4th July 2024

RESERVED MATTERS PLANNING APPLICATION, REFERENCE H09-1044-23, ERECTION OF 285 DWELLINGS INCLUDING PARKING, PUBLIC OPEN SPACE, DRAINAGE, INFRASTRUCTURE, LANDSCAPING, ACCESS, APPEARANCE, LAYOUT AND SCALE (PHASE 3) - OUTLINE APPROVAL H09-0521-14 AND RE-SUBMISSION OF H09-0845-22 AND H09-1118-22.

SECTION D-D
Scale 1:100

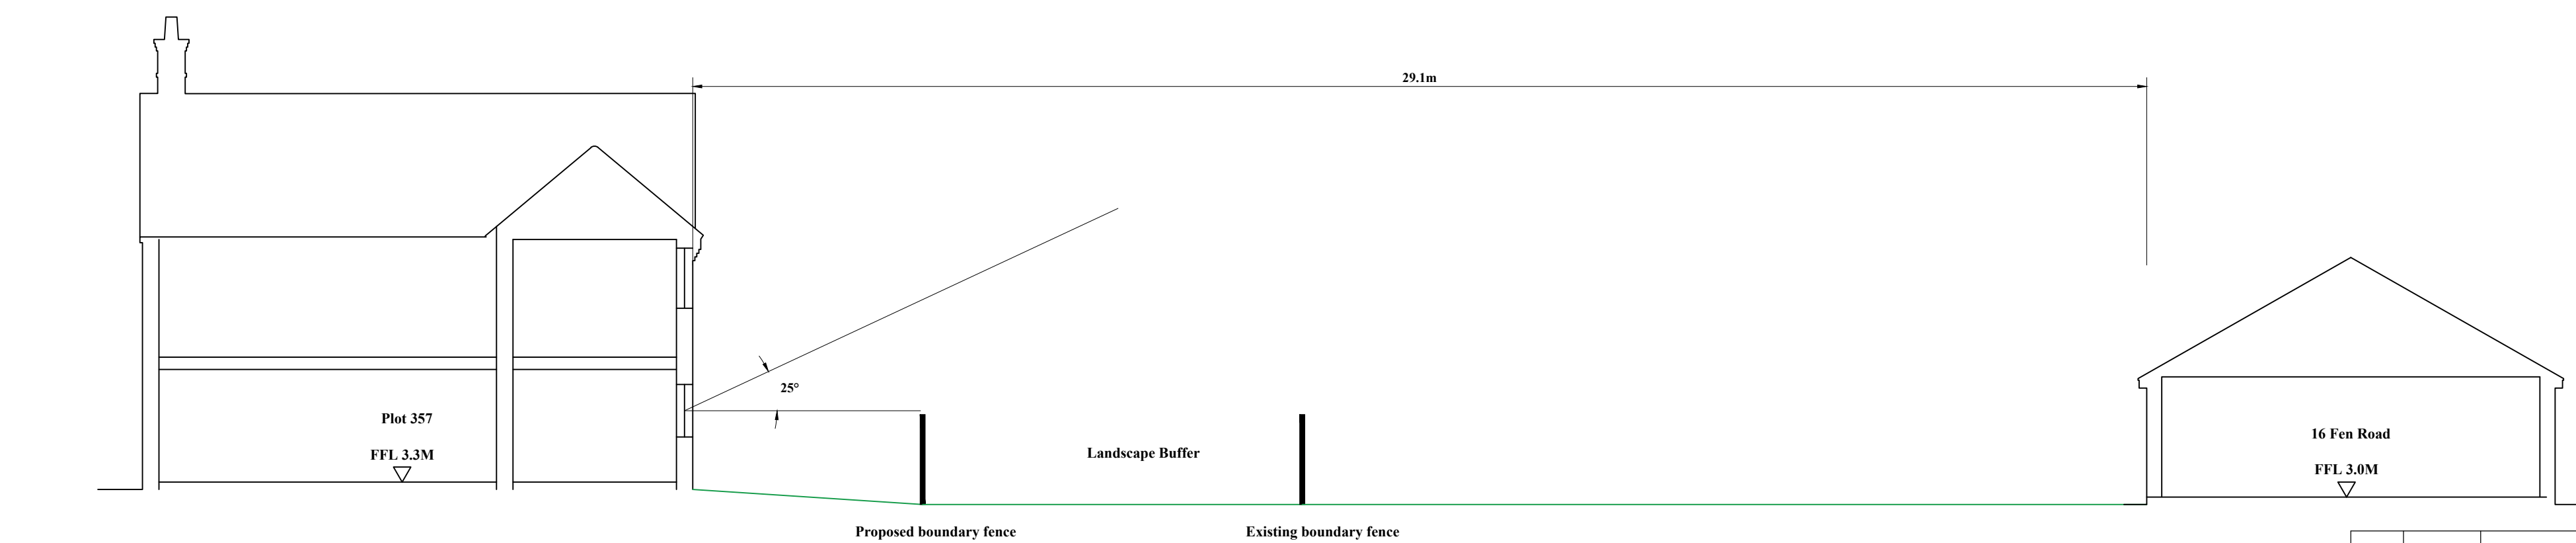
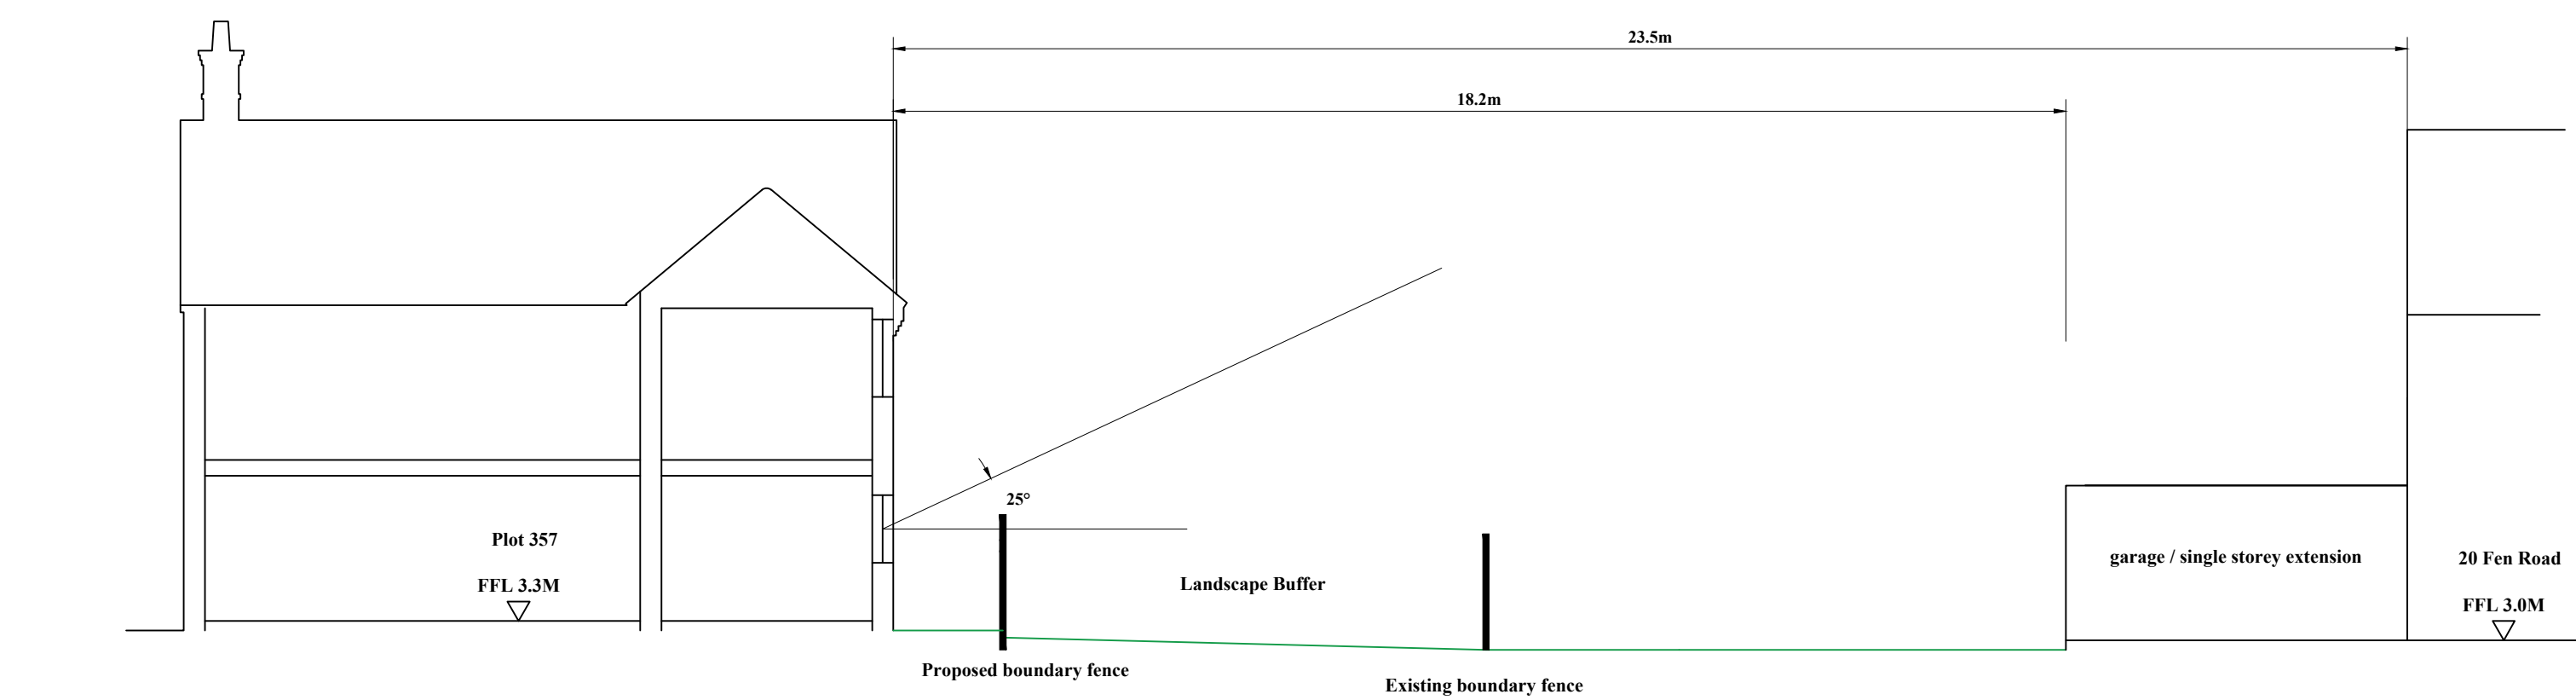
4. To address concerns over the position of plot 442 and its proximity to the SUDs attenuation basin, we have provided a further section to show the gently sloping sides of this feature and the fencing which separates it from plot 442. As you know, the attenuation basins are 'off line' and will only hold water temporarily during extreme weather events.
